**CITY OF ALBUQUERQUE
PLANNING DEPARTMENT
September 14, 2016
DRB Comments**

PROJECT # 1010832 APPLICATION # 16-70319

RE: Tracts 5-B-1-A-1-A et. al., Journal Center

PLAT OF TRACTS 5-B-1-A-1-A-1, 5-B-1-B-1-A, 5C-1A-1, 5C-1A-2, AND 5C-1B-1, JOURNAL CENTER

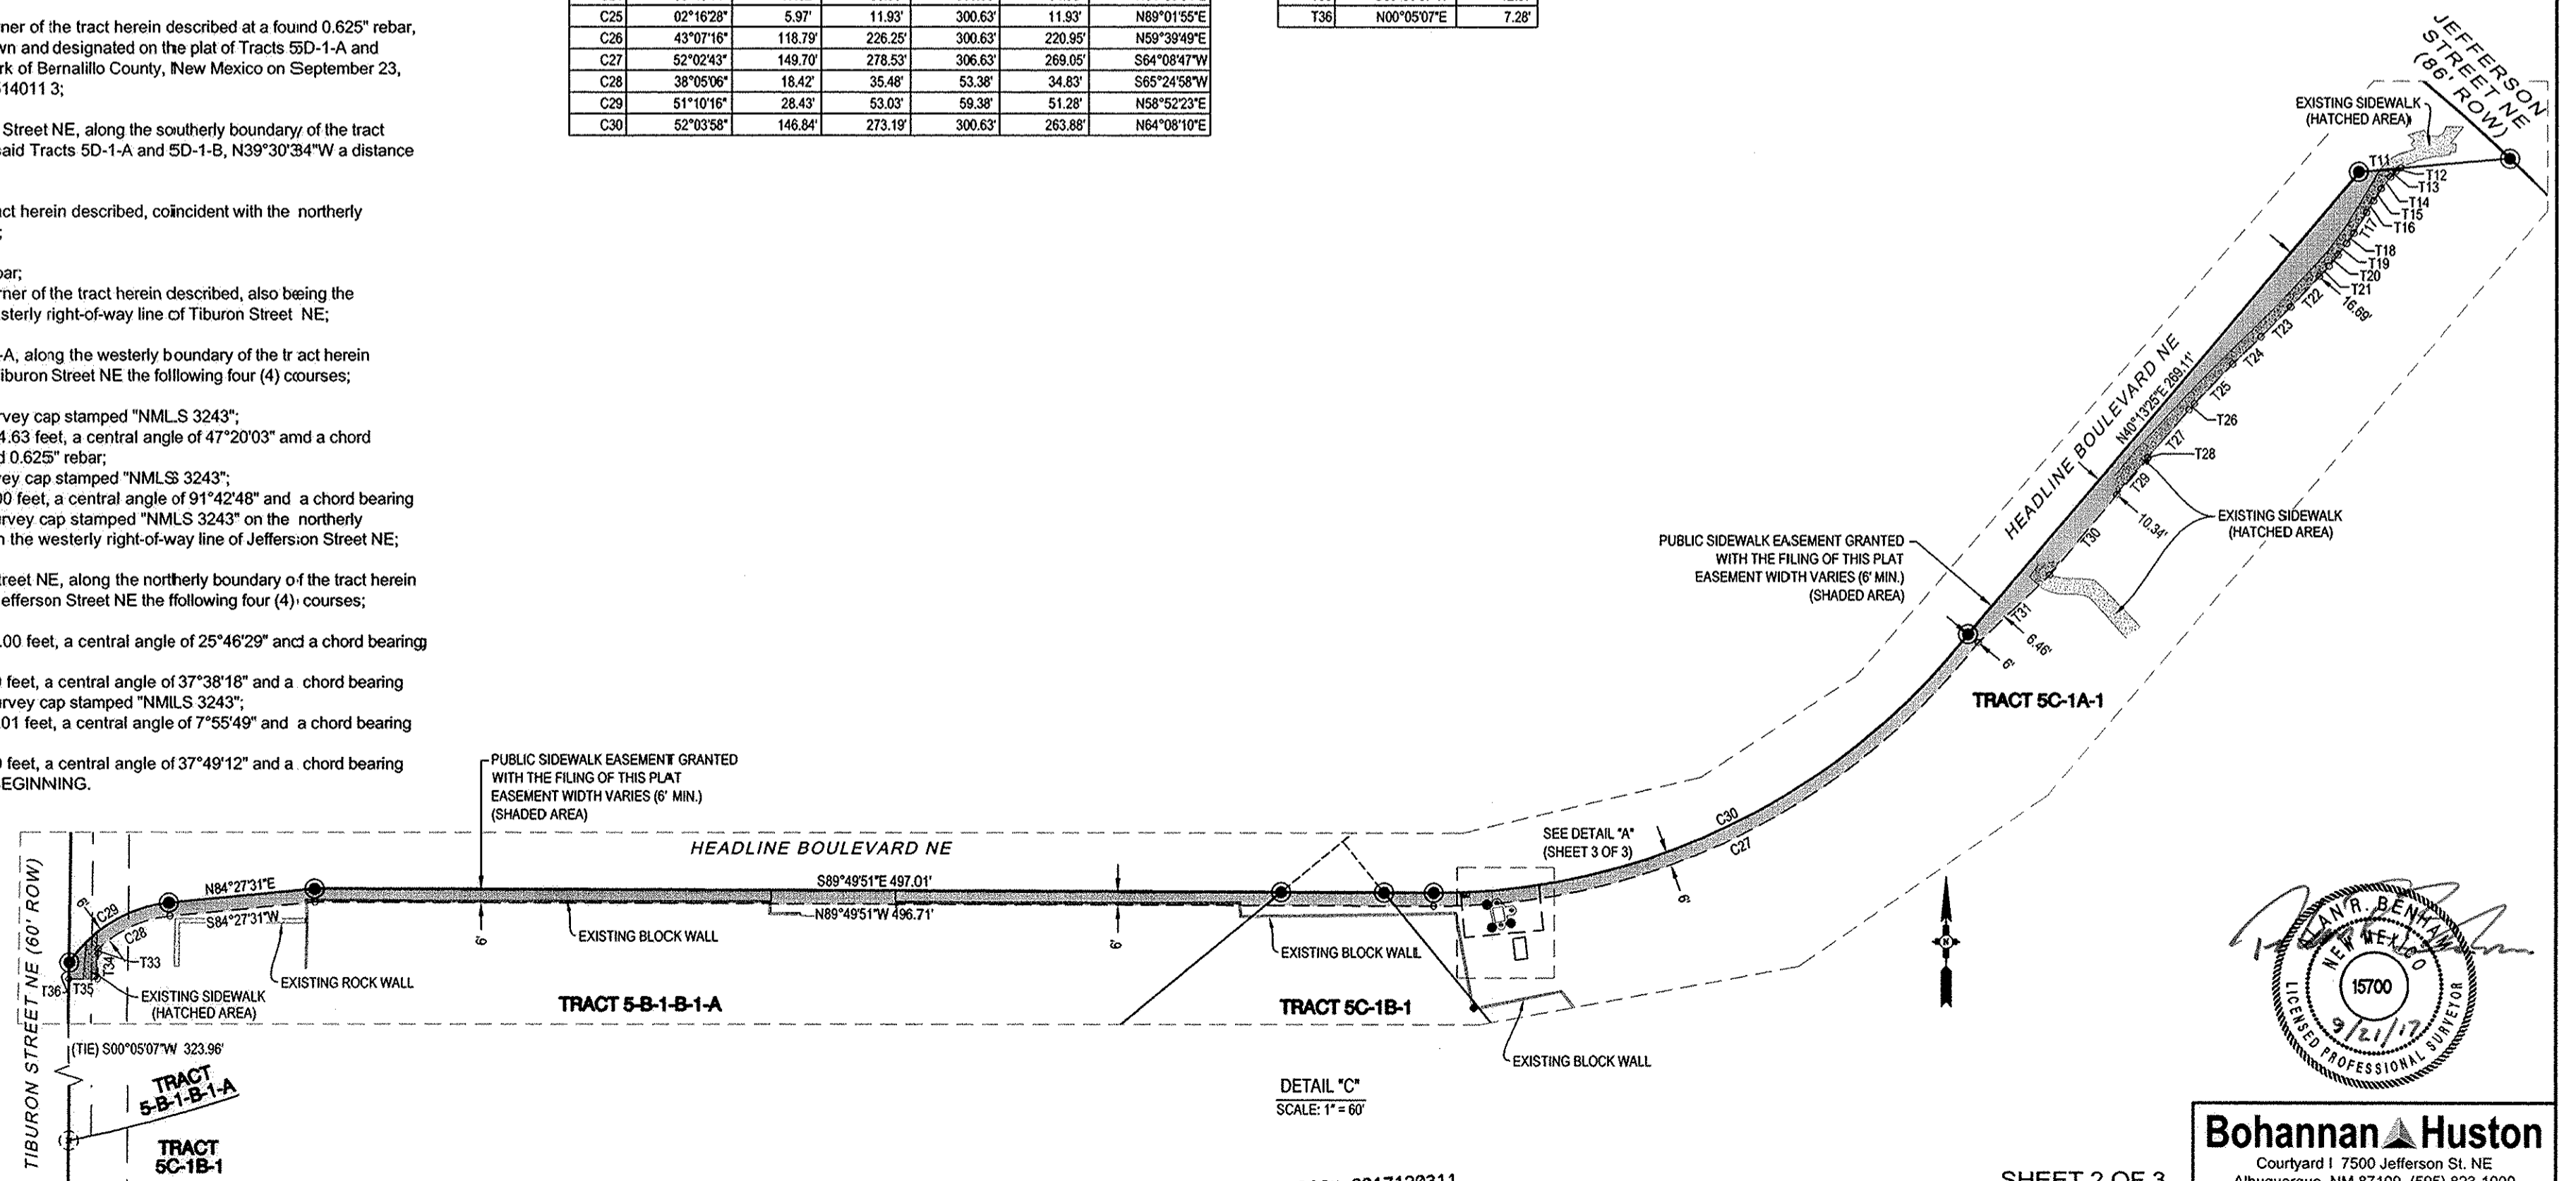
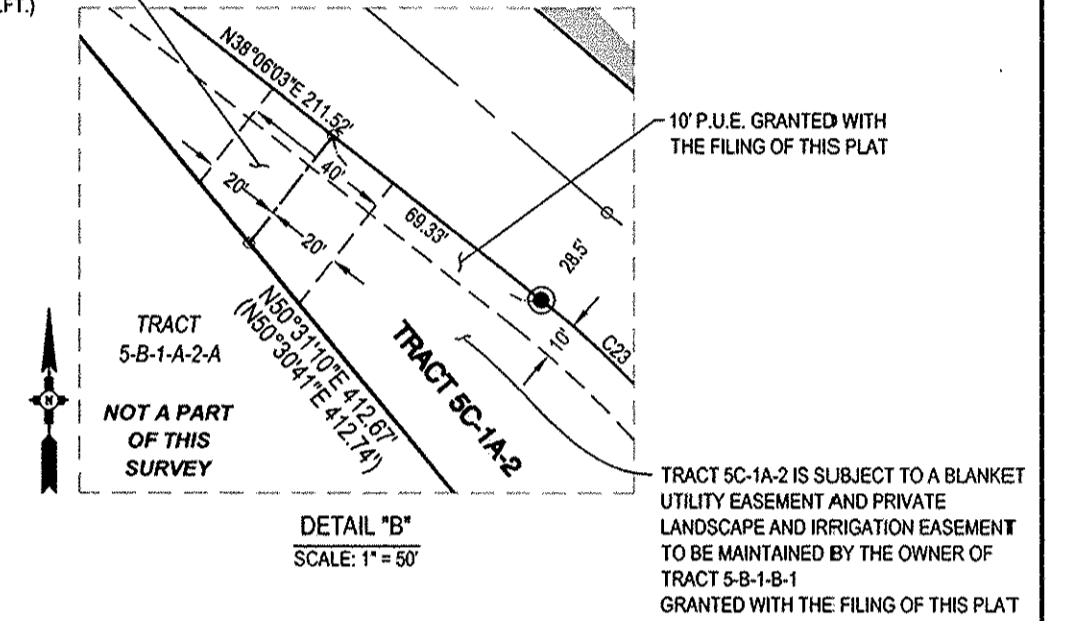
Remove Zoning Note (3) from Subdivision Data table.

Based on Quitclaims of R/W Tracts, a separate Free Consent and Dedication statement is needed for the City of Albuquerque; based on Irrigation Easement under proposed right of way, a revised dedication statement approved by the City Attorney is needed.

Maintenance of Easements (proposed Tract 5C-1A-2) needs to be noted on the plat.
